# KITTITAS COUNTY DEPARTMENT OF PUBLIC WORKS

## MEMORANDUM

TO: Community Development Services  
FROM: Taylor Gustafson, Environmental/Transportation Planner TG  
DATE: October 9, 2018  
SUBJECT: Public Works Review of Final Plat LPF-18-00007 (Suncadia Phase 3 Division 14)

DATE: 2018-09-26 JOB NO. 998-767-017-0100
DRAWN BY: C.A.F./R.F.G. SHEET 1 OF 5

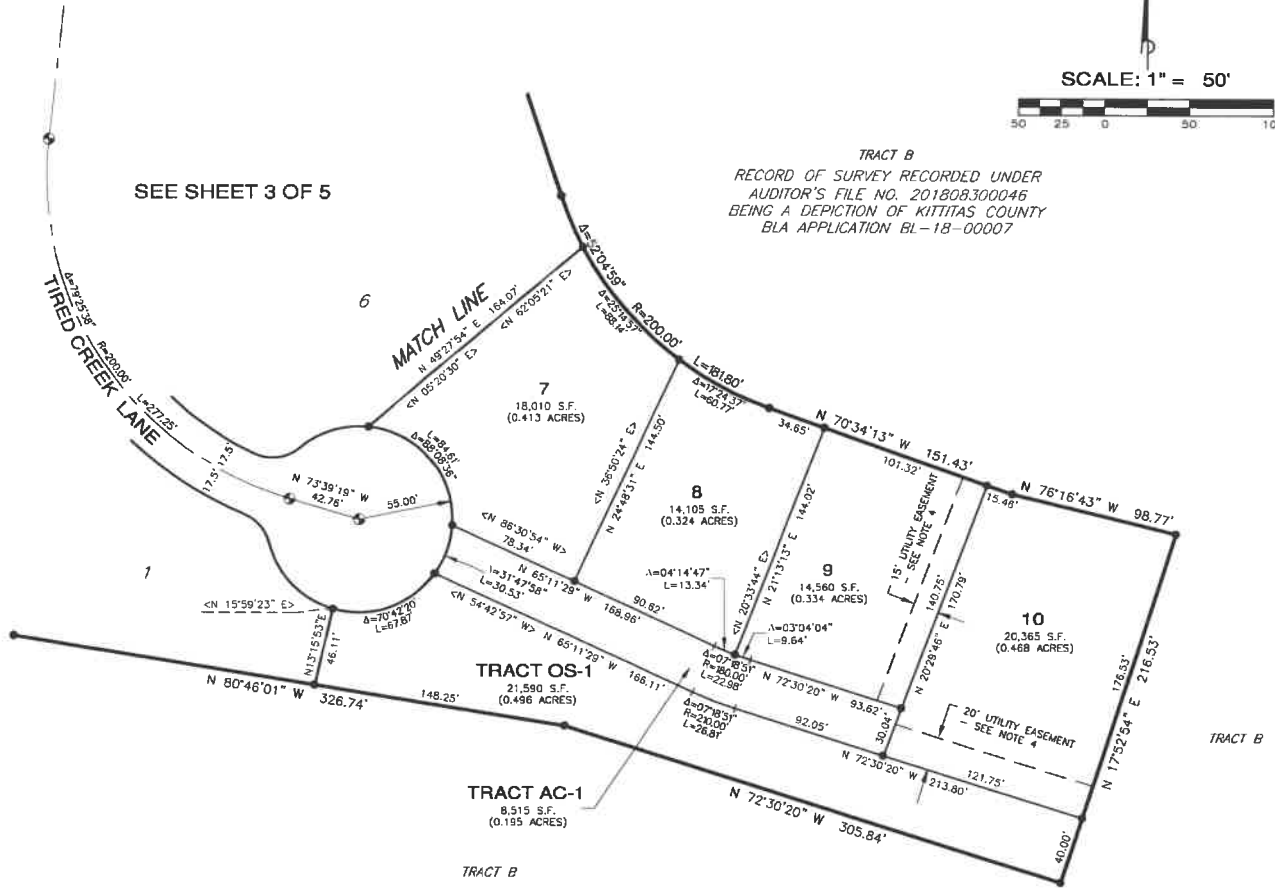
1. On sheet 1 the Recording Certificate is shown in two locations.
2. Sheets 3 and 4 are missing the surveyor stamp.
3. Please check the bearings and distances as shown on the access road North of Lots 3 and 4. If I retrace the access road from the N'most corner of Lot 3, I am unable to close on the NW corner of Lot 4.

DATE : 2018-10-11 | JOB NO. 998-767-017-0100
DRAWN BY: C.A.F./R.F.G. | SHEET 2 OF 5

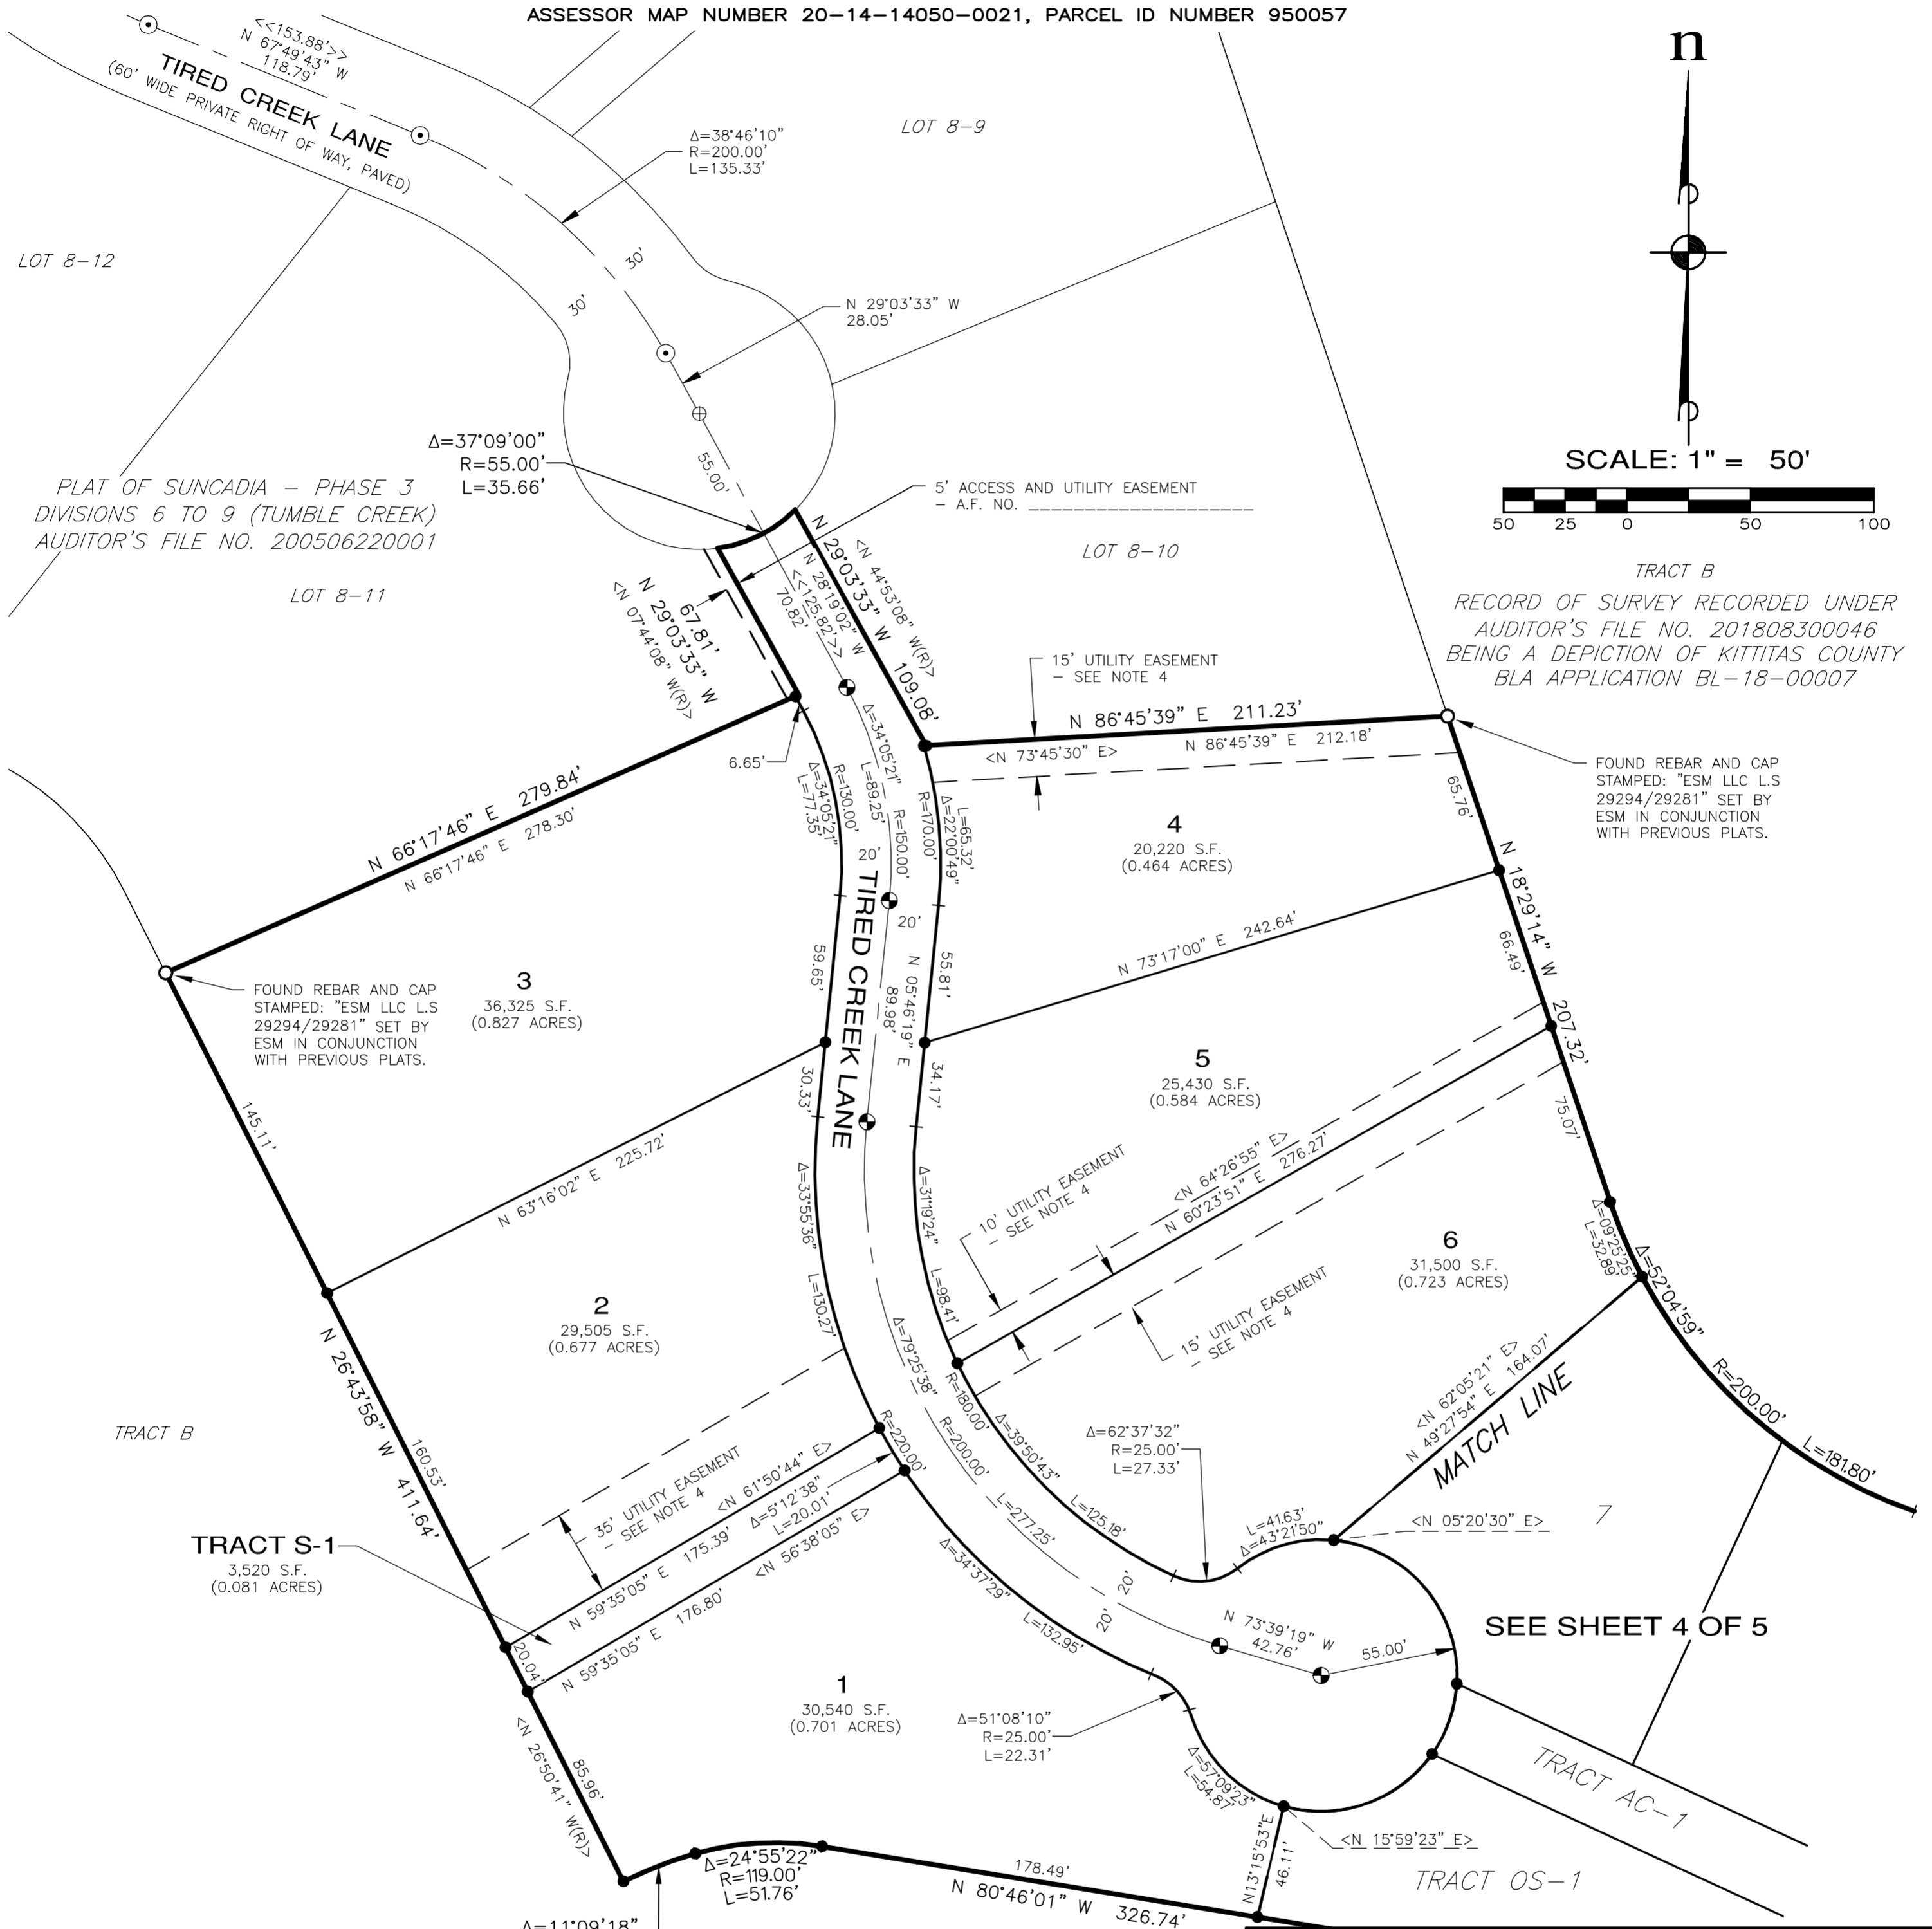
2. Tired Creek Lane Extension: Plans are showing a 35' right of way. R-O-W should be 60' on the face of the plat and be designed and constructed to Exhibit J (Rev. 1) to Development
